WOODMOOR

Water & Sanitation District No. 1

November 22, 2017

RE: The Beach at Woodmoor PUD/Preliminary Plan (PUDSP-17-003) and The Beach at Woodmoor Final Plat (SF-17-015) - REVIEW 2

The Beach at Woodmoor Filing No. 1
 Coronado Beach Drive -- Plan and Profile
 Water -- Plan and Profile
 El Paso County, Colorado

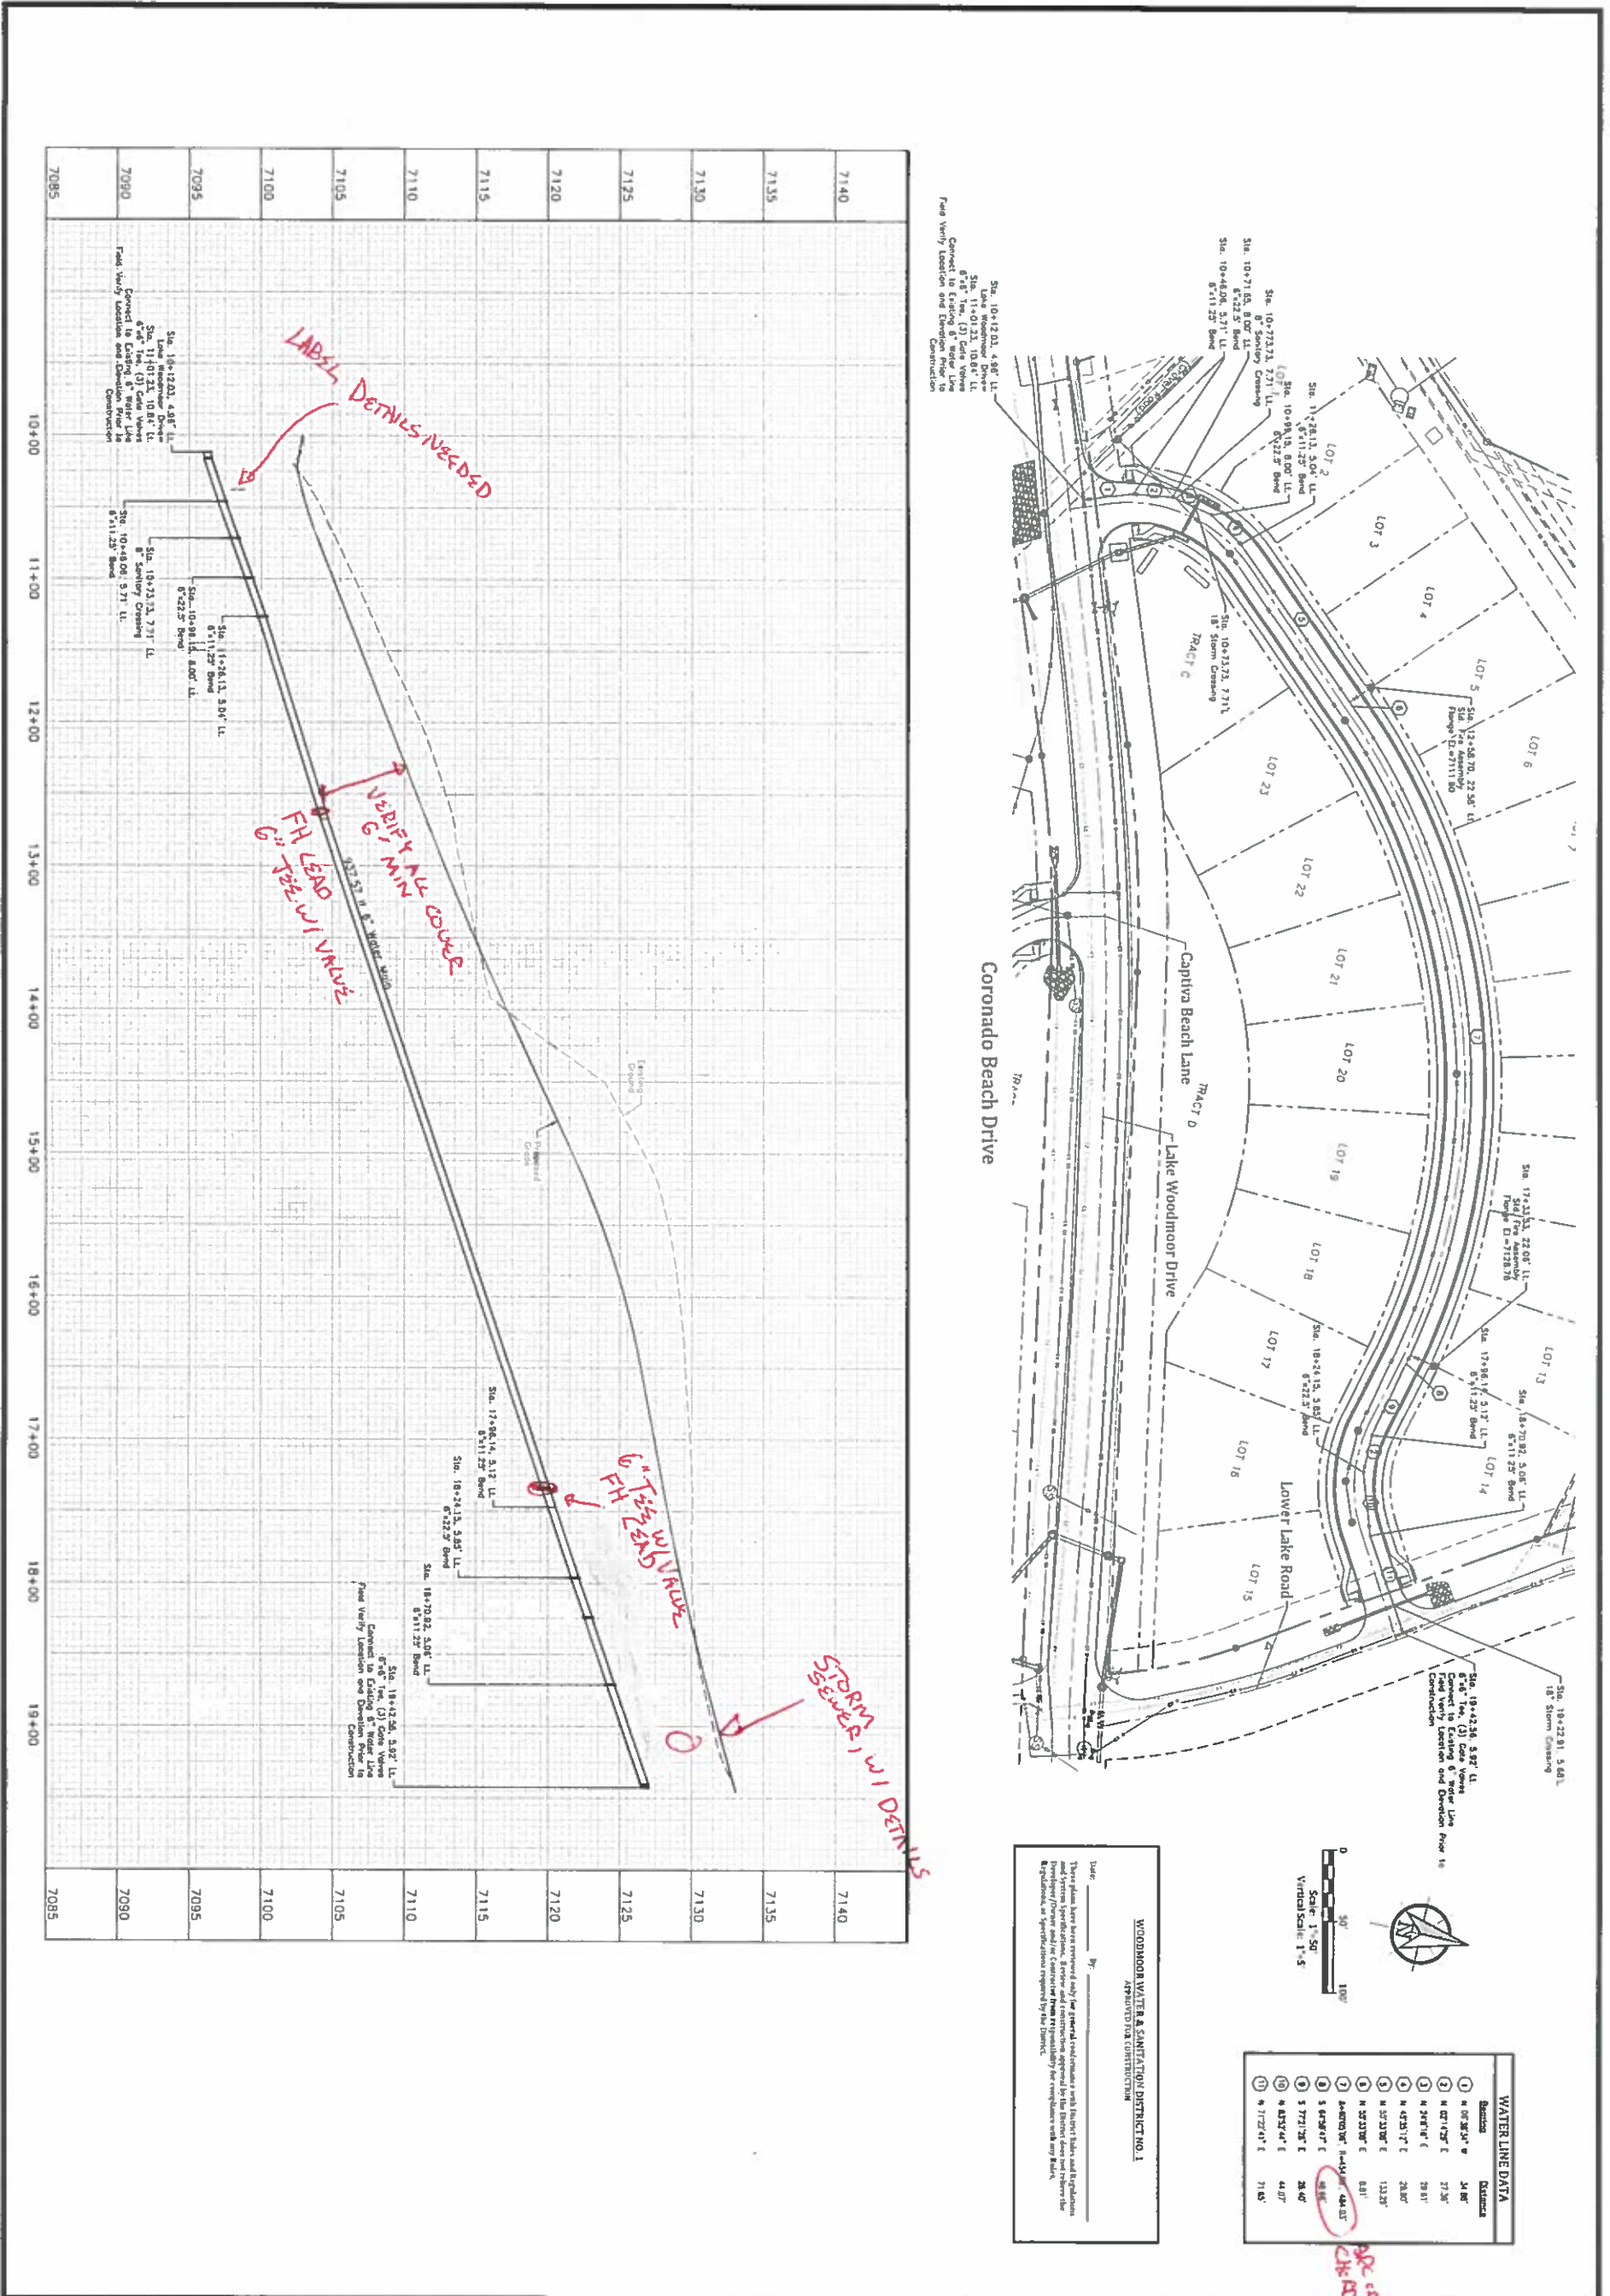
2. On Sheet 12 of 18, relocate hydrant from Sta 14+35.38 to highest practical point to east at end of cul-de-sac, approximately Sta 16+50.
3. Revise profiles to show all storm crossings with required labeling from WWSD System Specifications. Verify storm crossings conform to WWSD System Specifications Construction Detail W-3 (Water Crossing Under Utilities). Note all clearances.
4. Storm crossing at Sta 15+00 appears to interfere with water main.
5. Label all fire hydrant leads with valves on profile view.
6. Captiva Beach water main ties into 12" existing water main to the east. 12" line will need to be reduced to 6" for loop. Line south of main tie in will be capped and abandoned (MJ cap with kicker).
7. The existing water stub to serve the area north of Lake Woodmoor Drive will need to be abandoned in accordance with WWSD Rules and Regulations requirements.
